From: Malcolm Jenkins [REDACTED]
Sent: 22 March 2019 16:23
To: Andrew Wood
Subject: Planning Application FG/220/18/PL : Land adjacent to Elm Lodge, Tamarisk Way, Ferring, West Sussex - Revised drawings

Further to our recent email correspondence with Laura Gibbons, please find attached the following planning application drawings which have been revised to reposition the proposed site boundary and dwelling and now make no changes to the existing pond as agreed with Laura on 19th March 2019.

Drawing Title
PROPOSED LOCAL AREA
PLAN

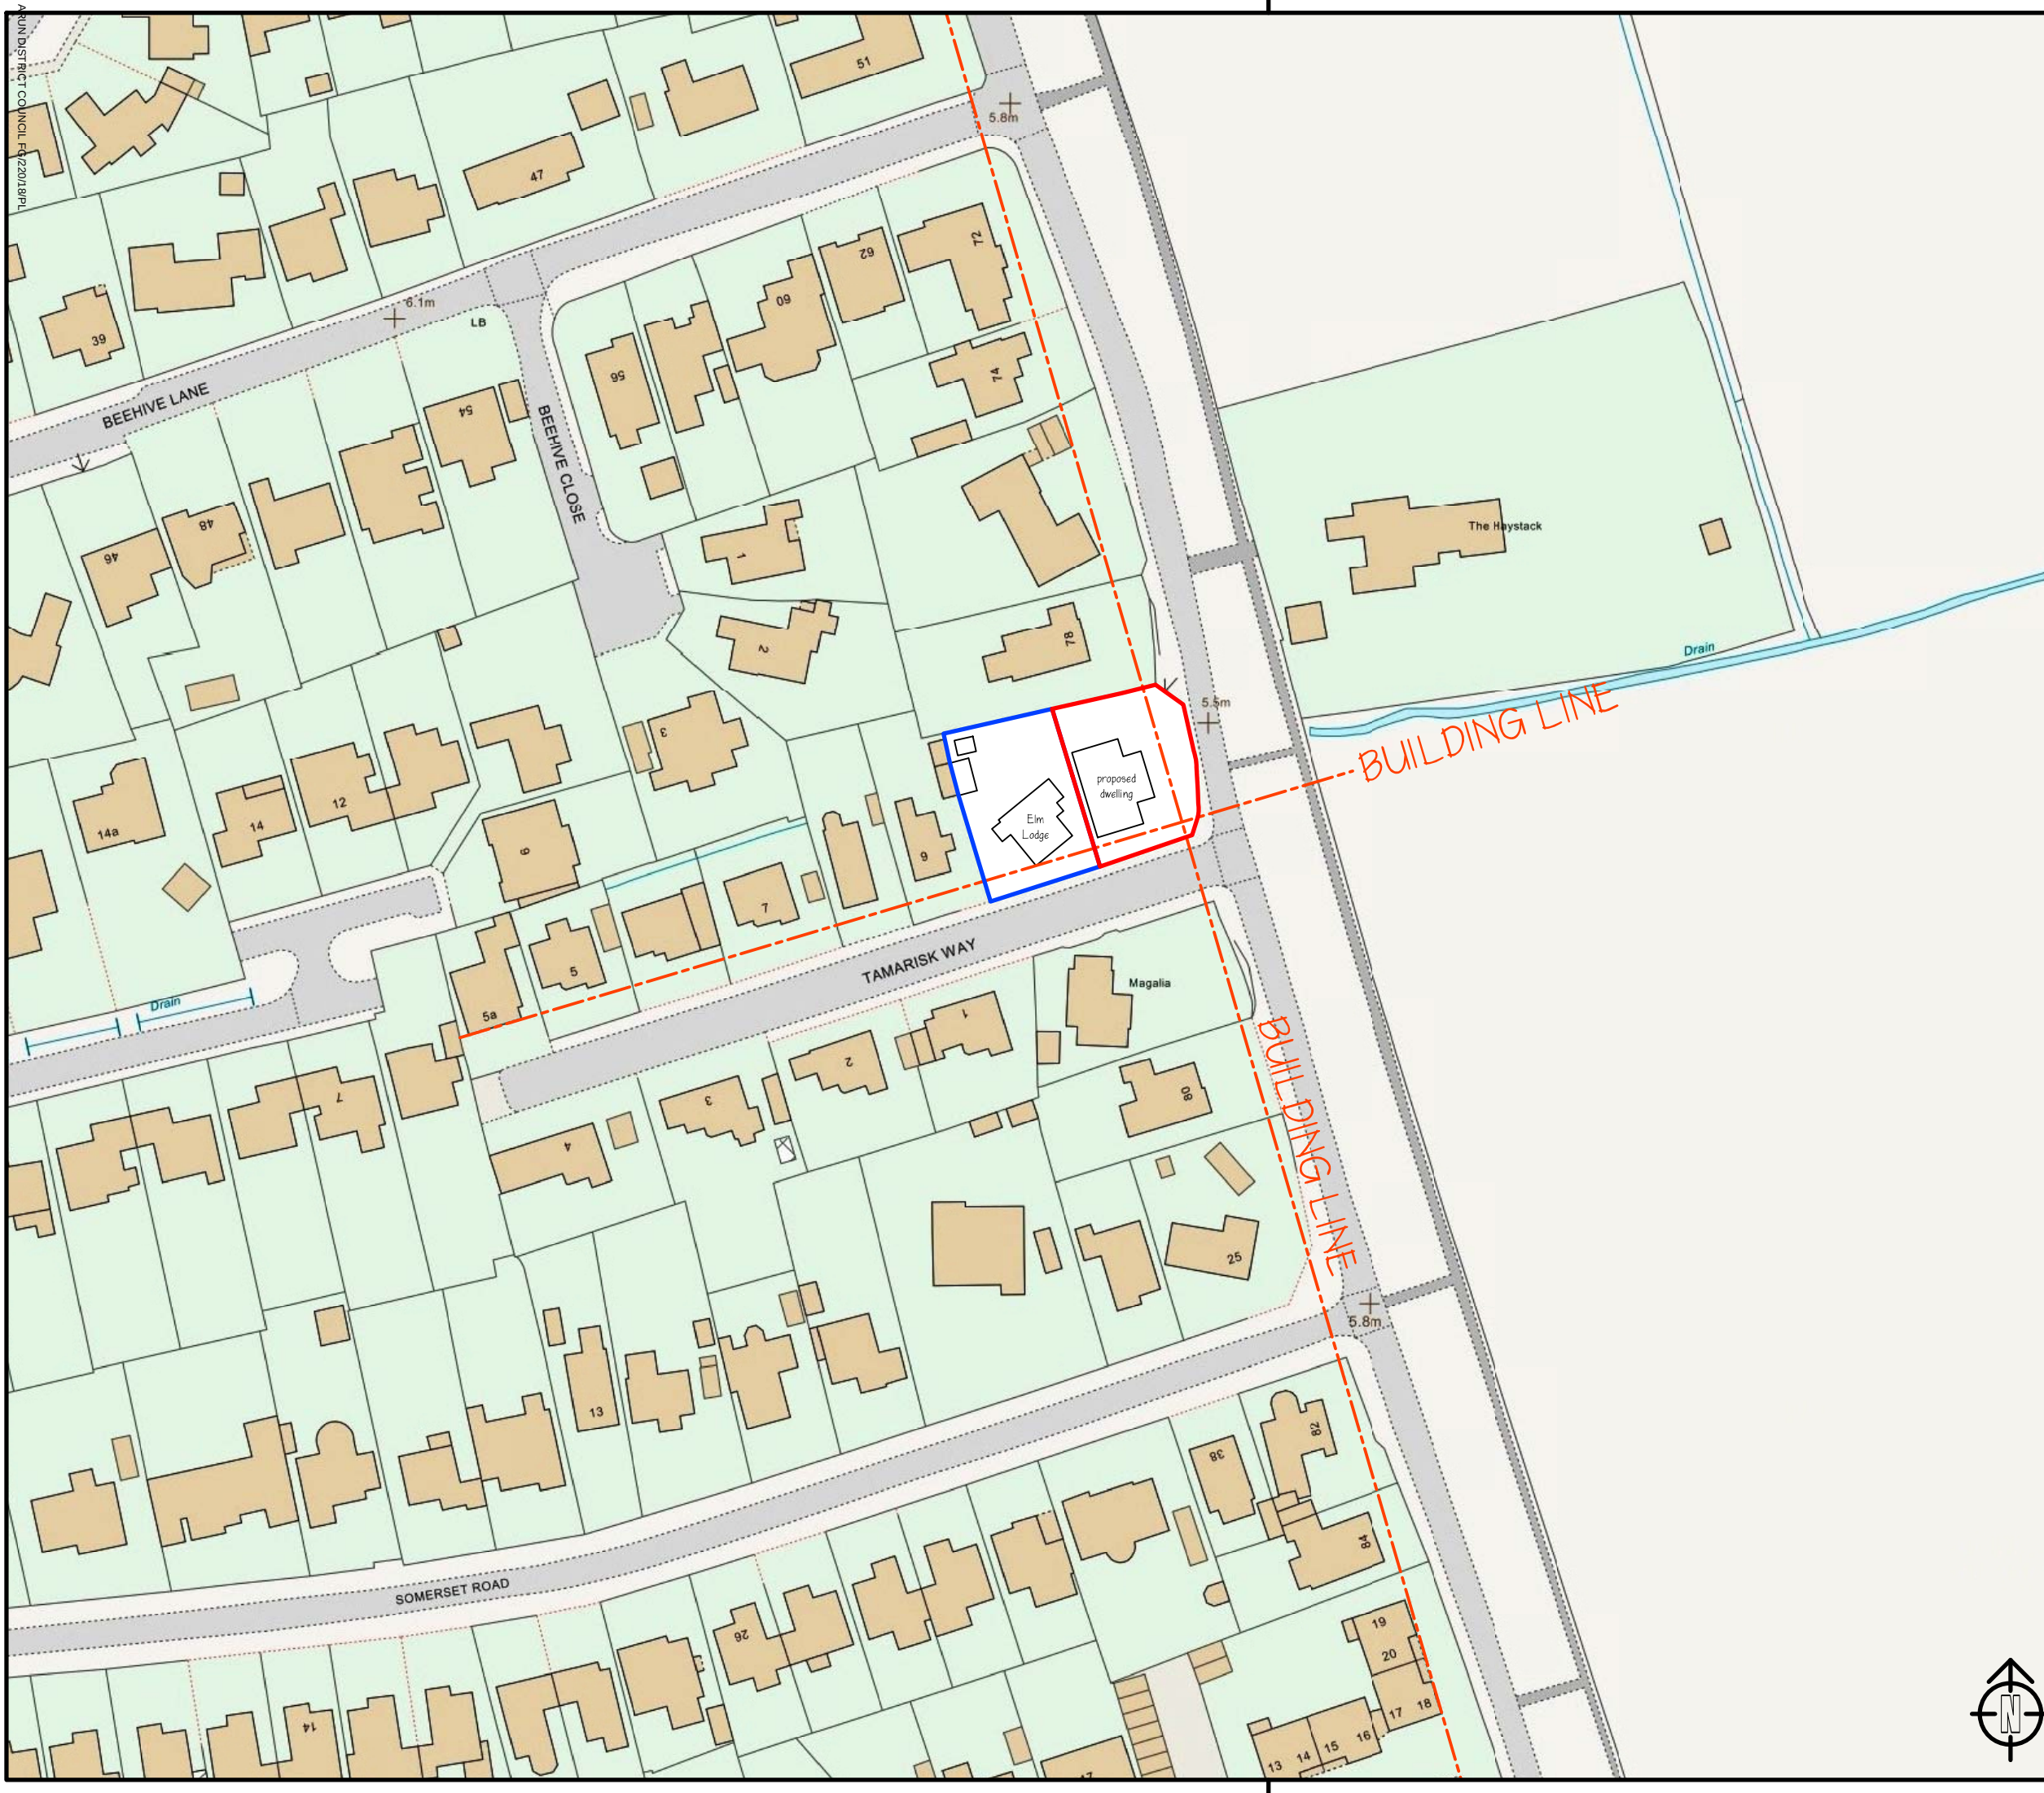
The proposed dwelling now sits well behind the Sea Lane building line. In re-siting the proposed boundary line, the plot of Elm Lodge will now measure 511sqm, and plot of the new dwelling will now measure 495sqm. These plot sizes well exceed the size of all plots on the North side of Tamarisk Way (averaging 380sqm) as well as the average plot size for Tamarisk Way as a whole (averaging 475sqm). We feel that the proposal complies fully with NPPF 2018 and Arun District Council's Adopted Local Plan 2018, and will provide a high quality, sustainable and harmonious addition to both Tamarisk Way and Sea Lane.
